CITY OF ALBUQUERQUE

December 1, 2017

**RE: Townhomes For Greg Lobberegt
2400 Marie Park Dr. NE
Request for Temporary C. O. – Not Accepted
Engineers Stamp Date 2/6/17 (H22D026)
Certification dated: 11-30-17**

DRAWING TITLE:
GRADING & DRAINAGE PLAN

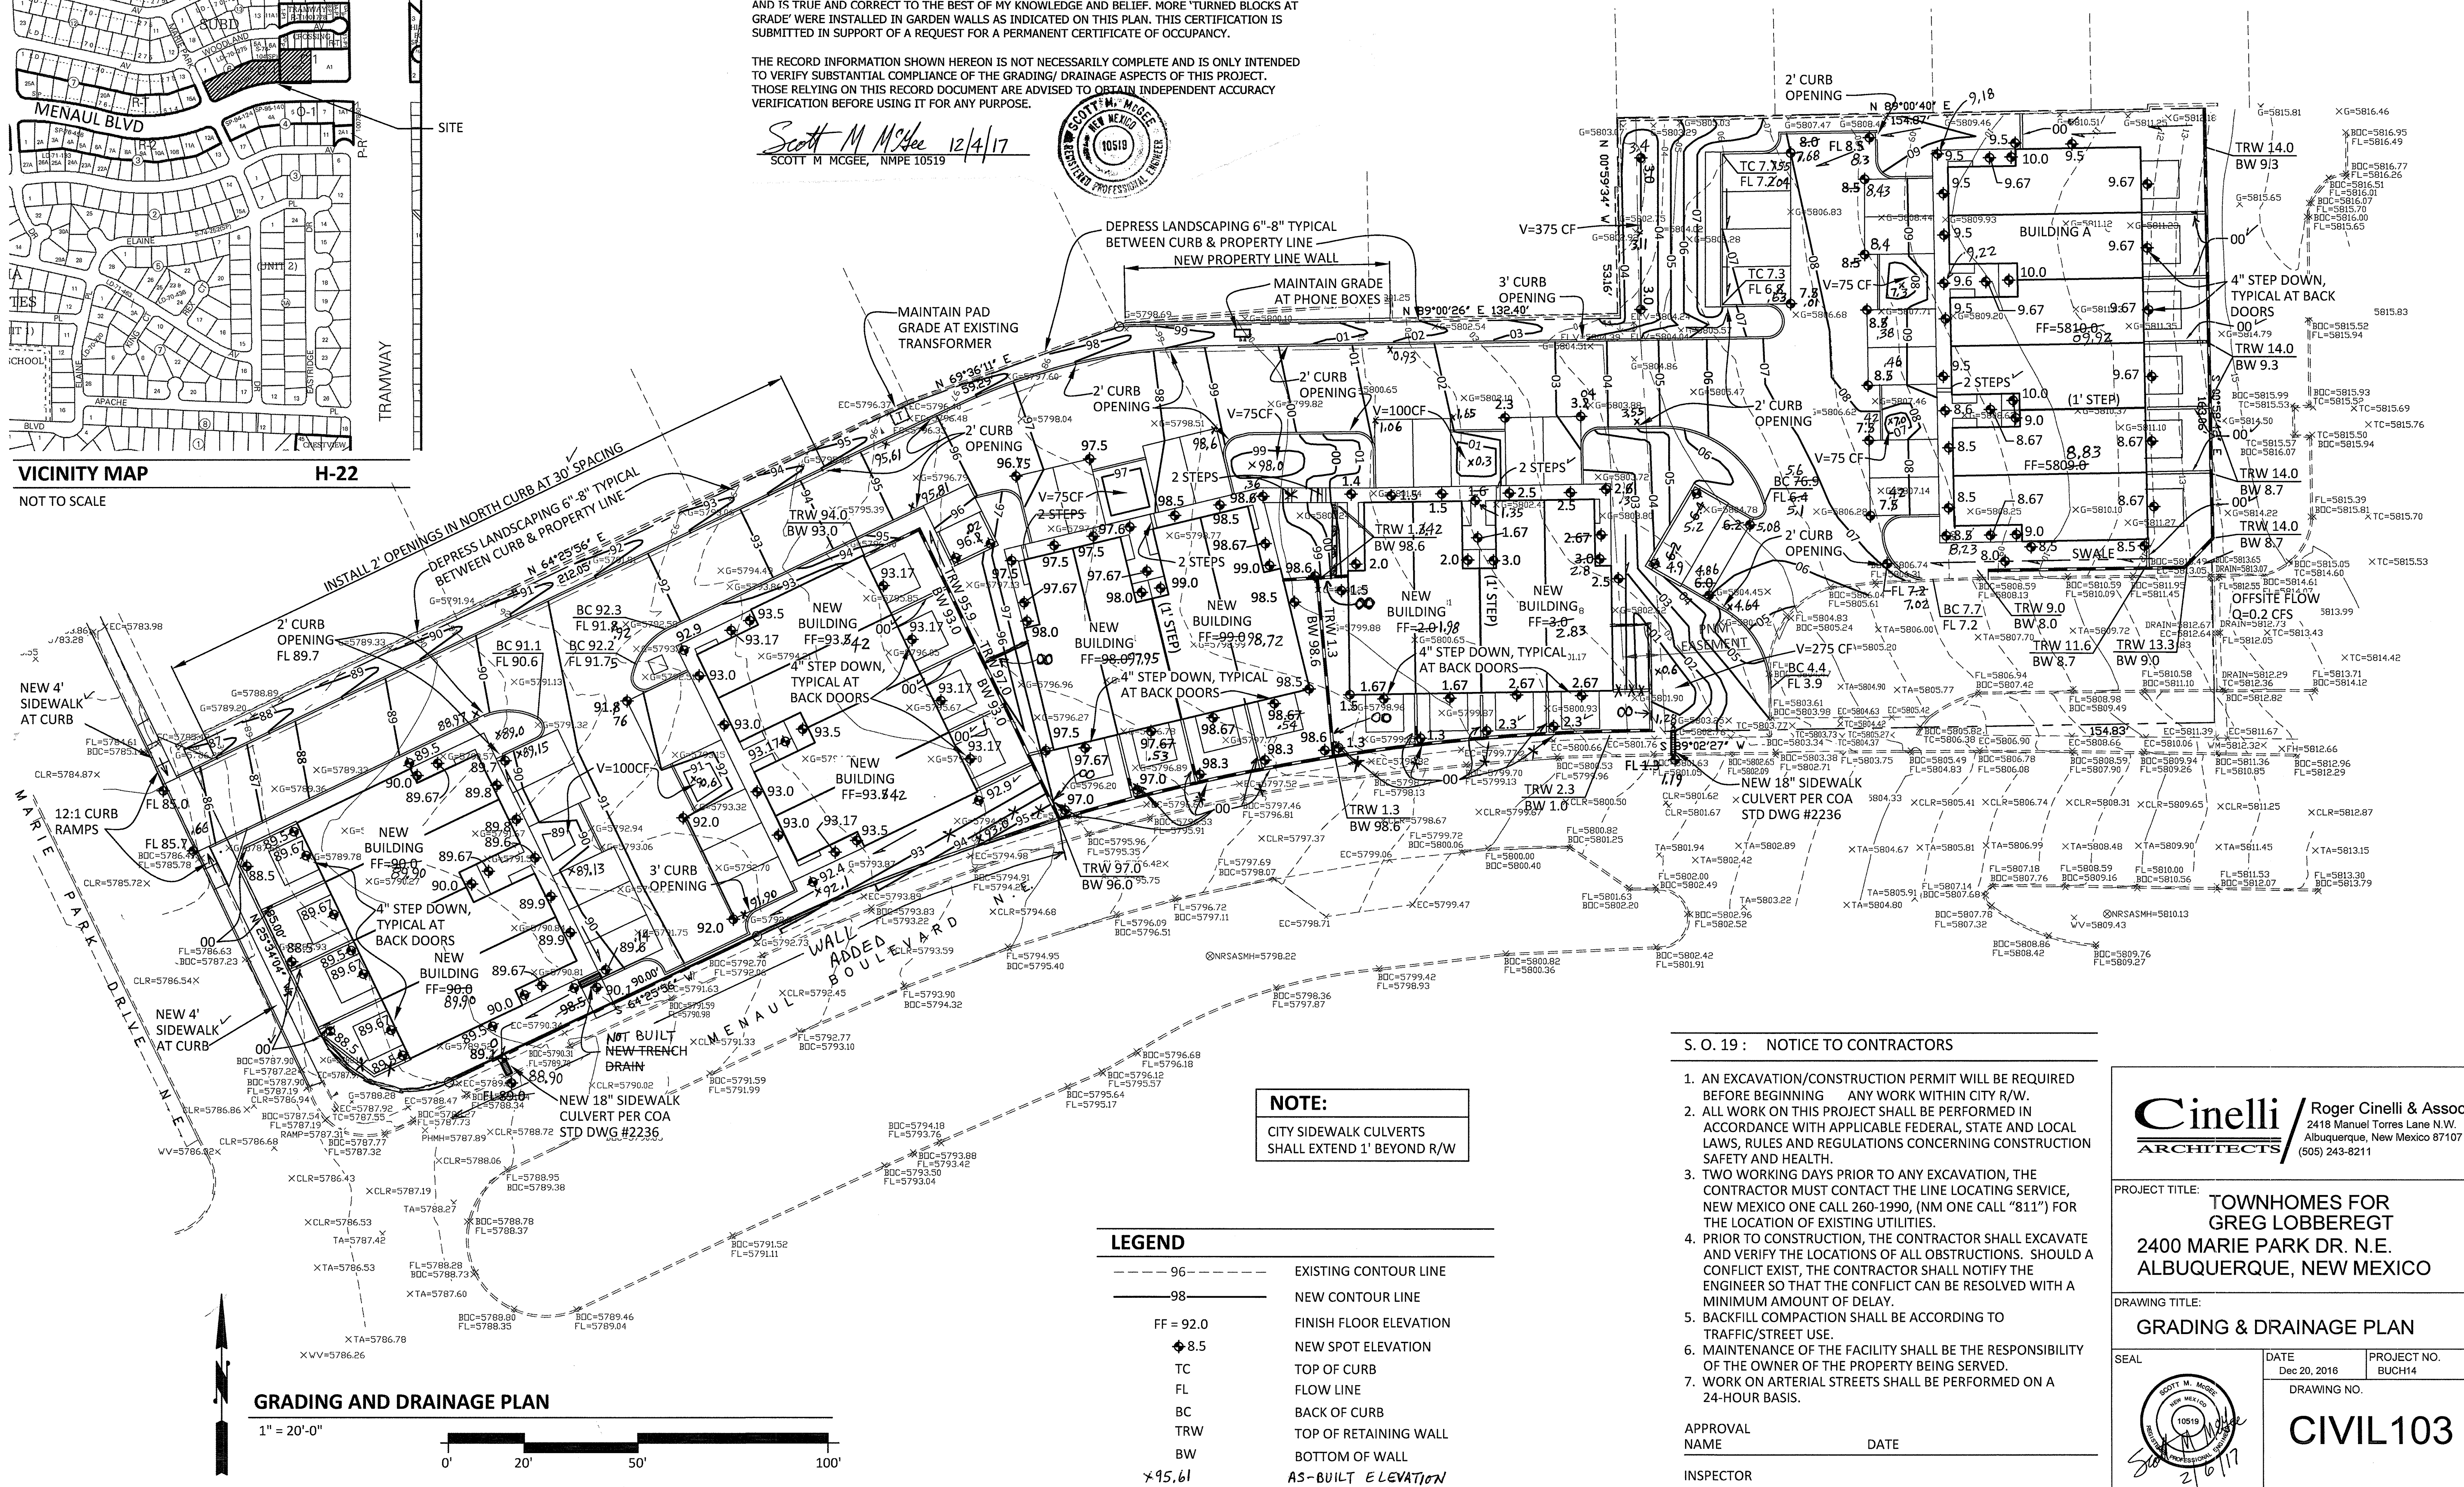
- Engineer certification must show as built location of all drainage through walls.
